PLANNING CONSULTATION RESPONSE

Application No	2026/0409 & 0410
Proposal	2026 0409 & 0410 (PP & LBC) Internal & External Alterations Part Retrospective 33 Darton Road Cawthorne
Address	33 Darton Road Cawthorne
Date of Consultation Reply	280726
Consultee	Tony Wiles Senior Conservation Officer

1 X Window - W8 (Side elevation, Living room, casement window with no centre mullion)

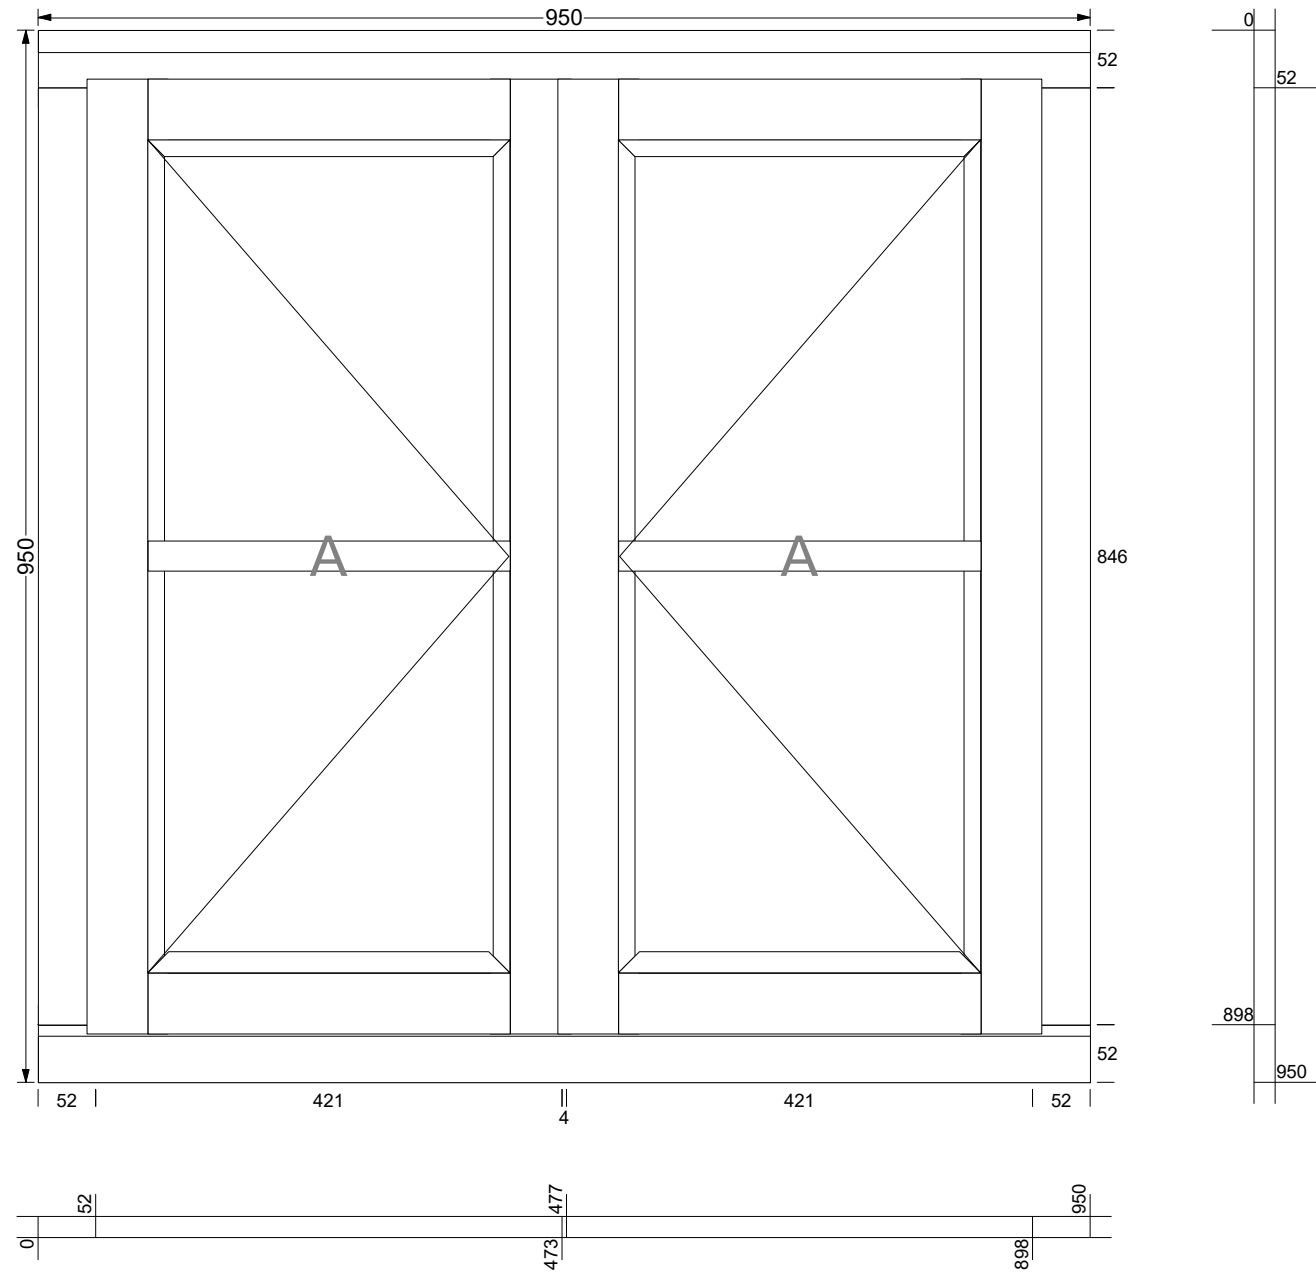
The works include a number of matters that may reasonably be regarded as repair, having been undertaken on a like-for-like basis. For example, the roof has been fully repaired using stone roofing slates and the rainwater goods have been renewed with sympathetic materials. The submitted plans indicate the renewal of all rainwater pipes and soil pipes in Alumasc Heritage. Some areas of perished stone, notably to the roadside frontage, have also been replaced with matching stone and repointed. These areas are not shown on the plans, although the area to the rear, around the modern underpinning, is detailed and this work has already been completed. I have no concerns with these elements. Discussions took place with the applicant some months ago regarding the nature and detail of the works already carried out. However, the submitted plans also include additional new works that merit further consideration. These principally comprise the replacement doors and windows, together with internal alterations at ground and first-floor level. The existing windows are modern and vary in design, fixtures and furniture, none of which appear to be original. On that basis, I would not object to their replacement in timber as generally indicated, although the submitted information is somewhat limited in detail. Ideally, representative window and door elevations at 1:20 or 1:10, together with 1:5 cross-sections, would provide an appropriate level of detail. I have included a draft condition below to address this point. However, following discussion with the applicant, this may not be necessary if amended plans or sufficiently detailed manufacturer's information for the proposed windows and doors is submitted.

- All new stonework shall match the existing and utilise natural sandstone with matching course heights, face dressing and overall appearance.
- All replacement windows and doors shall be constructed in timber. Full details of their design, construction and finish (including details of heads and cills, means of opening and glazing pattern) shall be submitted to and approved in writing by the local planning authority before the commencement of the relevant site works. The details shall include an elevation at 1:20 or 1:10 scale of each door or window type and 1:5 scale cross-sections. Development shall be carried out in accordance with the approved details. * **Note this may not be required if we receive adequately detailed and updated plans.**

- All new windows and doors shall be mounted a minimum of 100mm in the reveal.
- All rainwater goods and soil pipes shall be in aluminium (Alumasc Heritage or similar) and decorated black.

Drawn CD
Date April 2026
Scales 1:100 - 1:50 - 1:1250 @ A2
Drawing No. 25116 - 0302 - R06

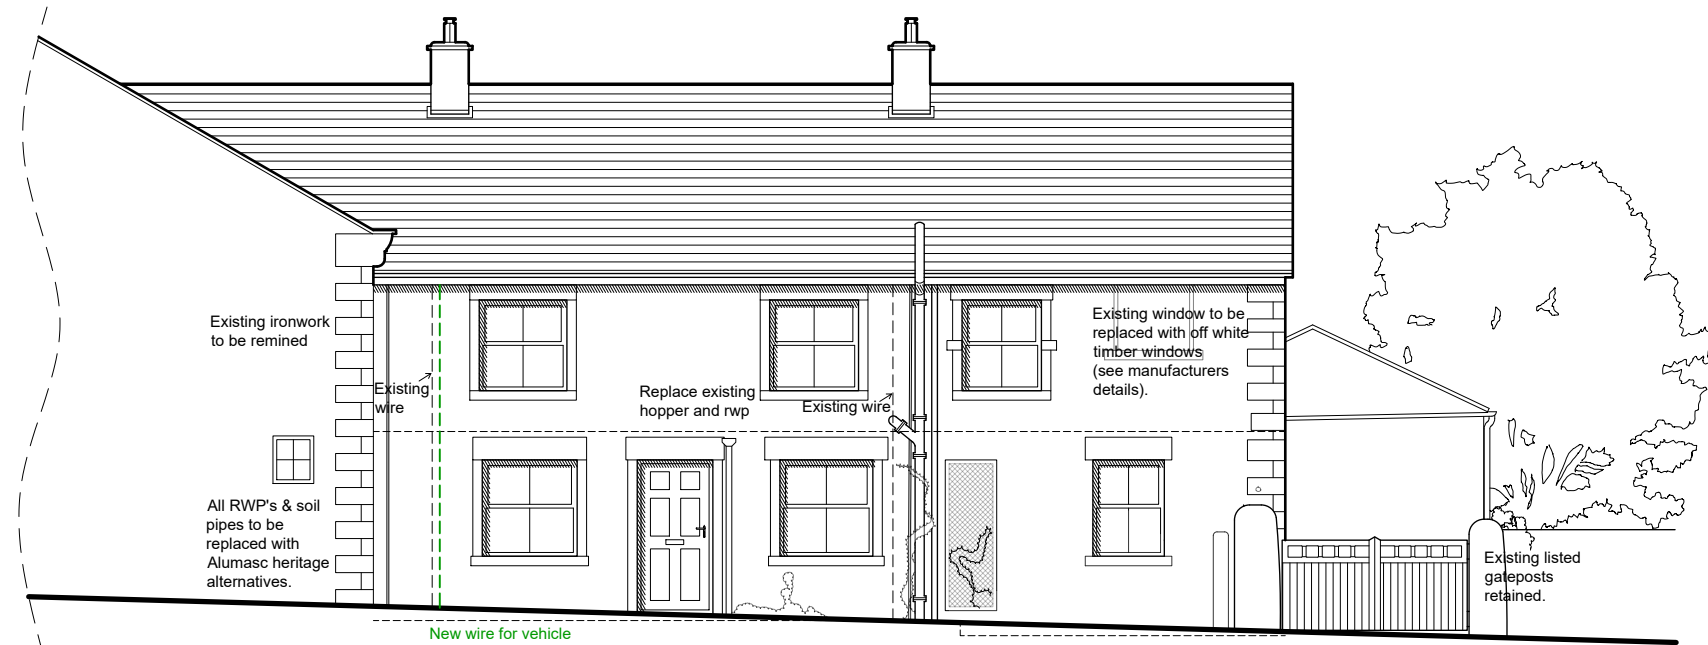
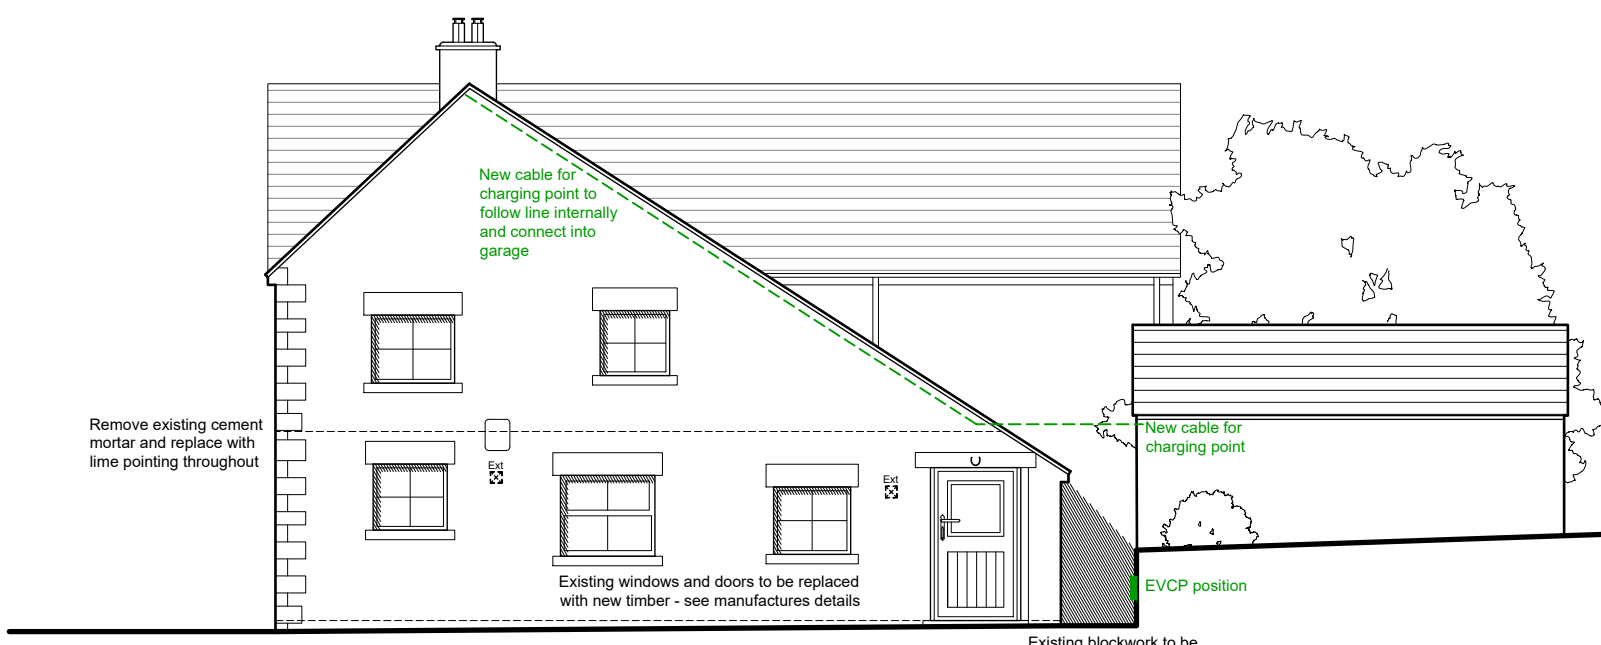
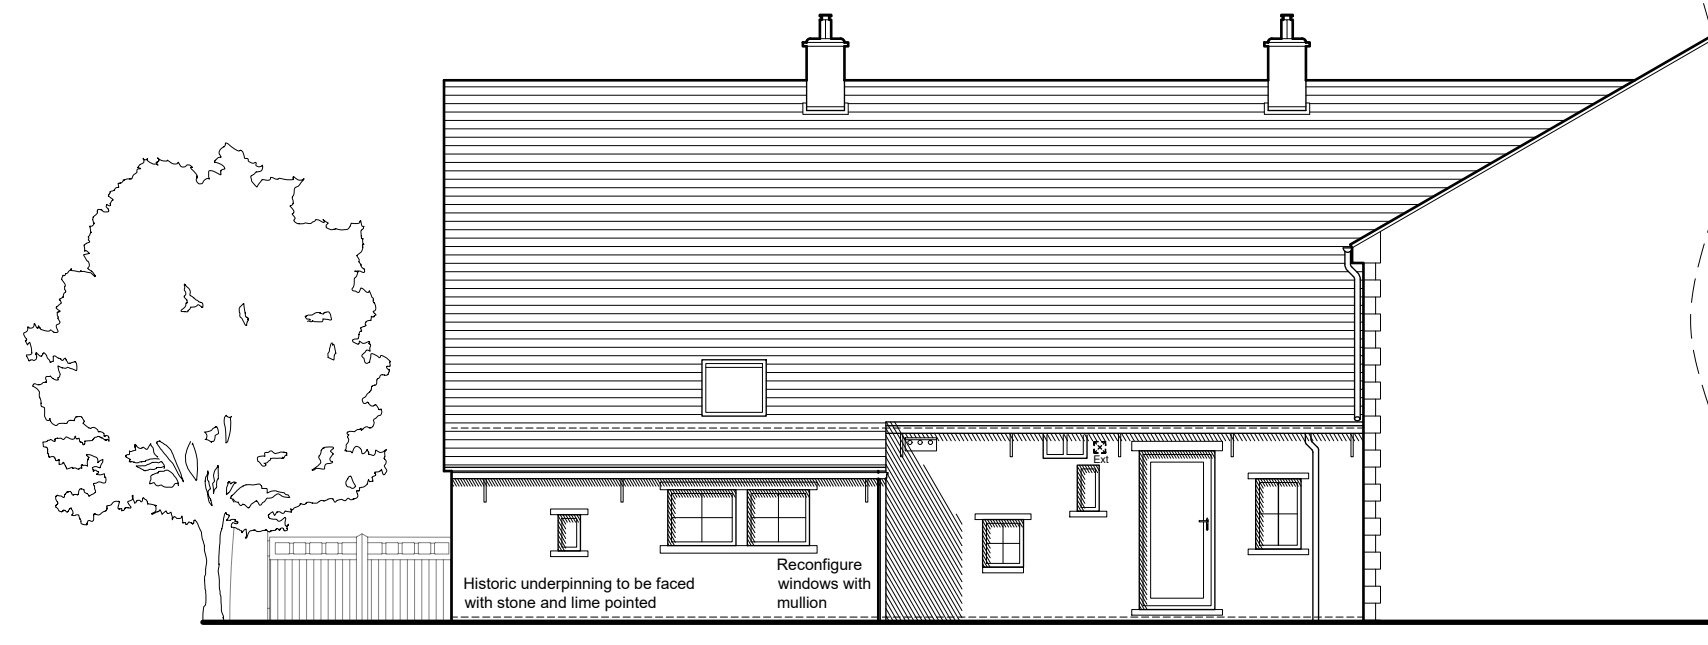
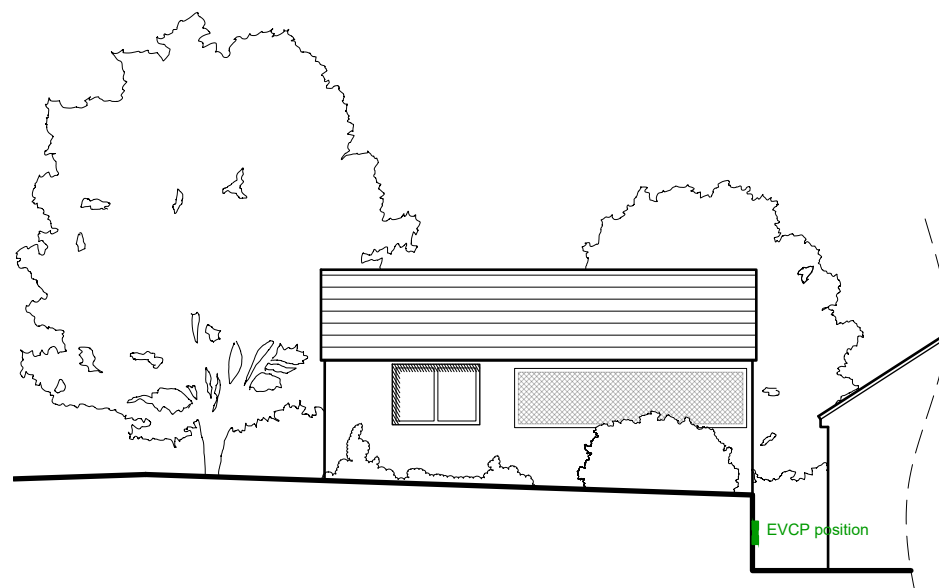
There are also a small number of additional matters to resolve. These relate to the garage door, which I understand has already been replaced, and the proposed solar panels within the garden. Neither item is currently shown on the submitted plans, and this information is required.
